STATE OF NORTH CAROLINA  
DEPARTMENT OF TRANSPORTATION

**Addendum No. 1**

RE: Contract ID C203230  
WBS # 13CR.10111.13 etc.  
State Funded

**Buncombe County**

PROJECT NO.	SHEET NO.	TOTAL SHEETS
13CR.10111.13 13CR.20111.11	4

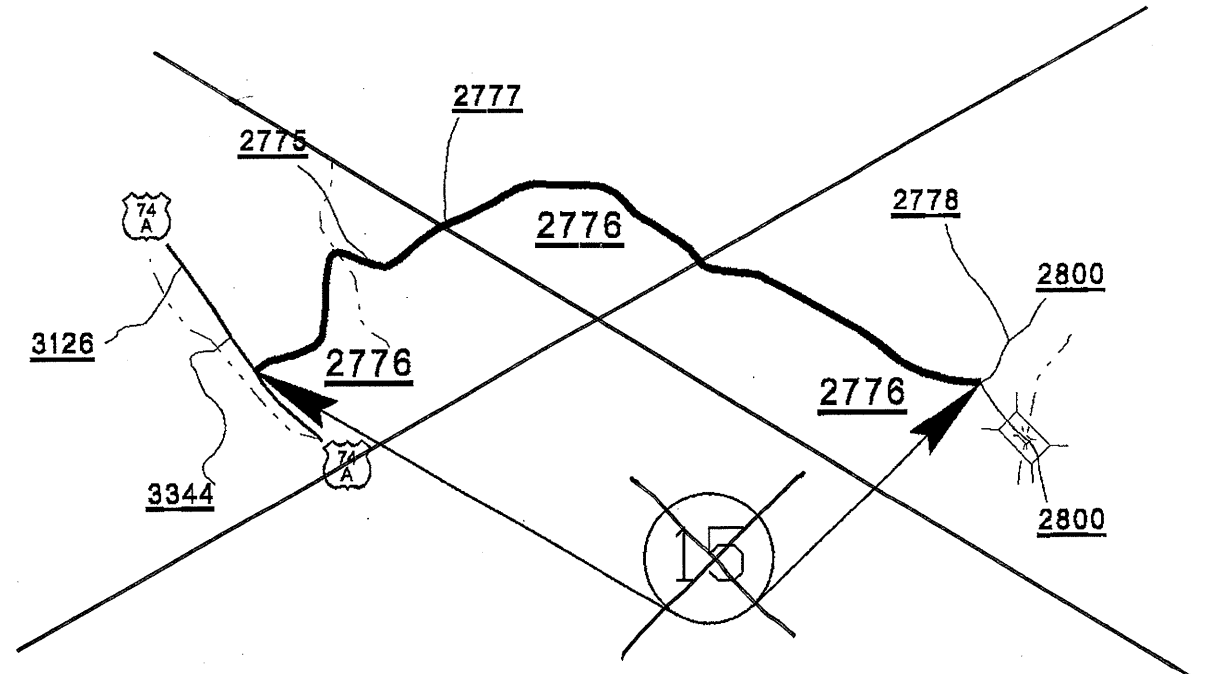
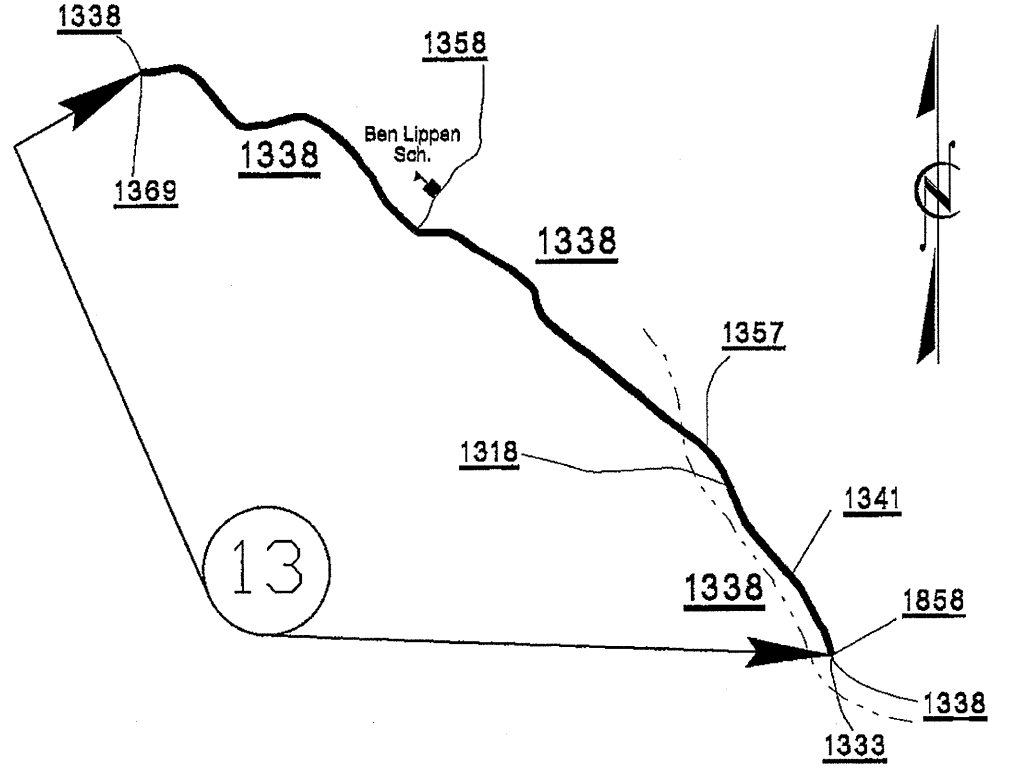
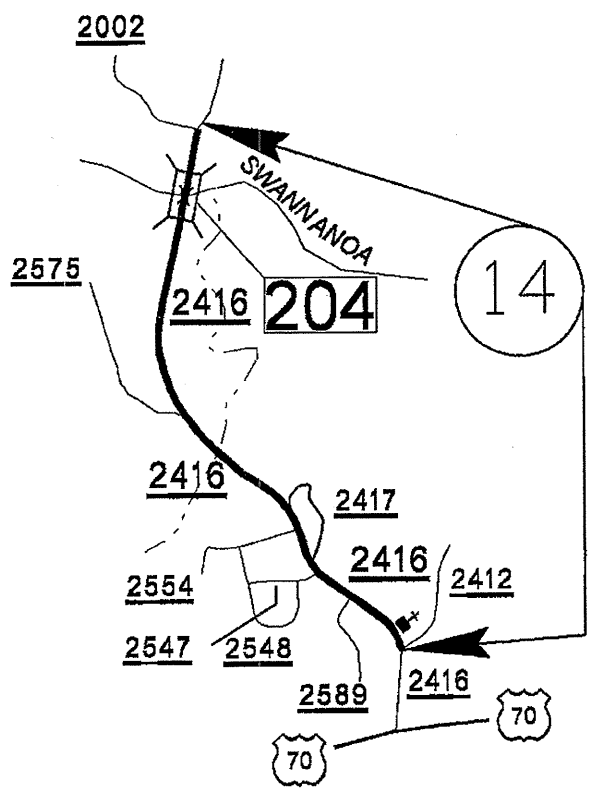
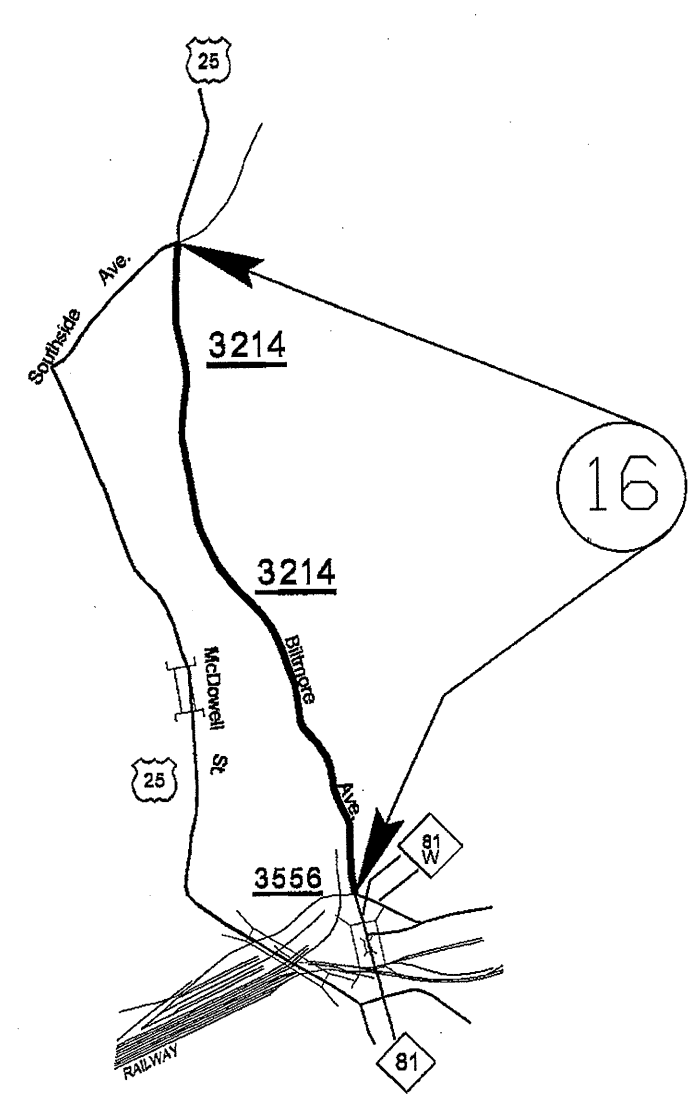
On Sheet No. 4 Map #15 has been removed. Please void Sheet No.4 in your plans and staple the revised Sheet No. 4 thereto. New Sheet No. 4-A has been added to show the new Map #15. Please staple New Sheet No. 4-A after revised Sheet No. 4 in your plans.
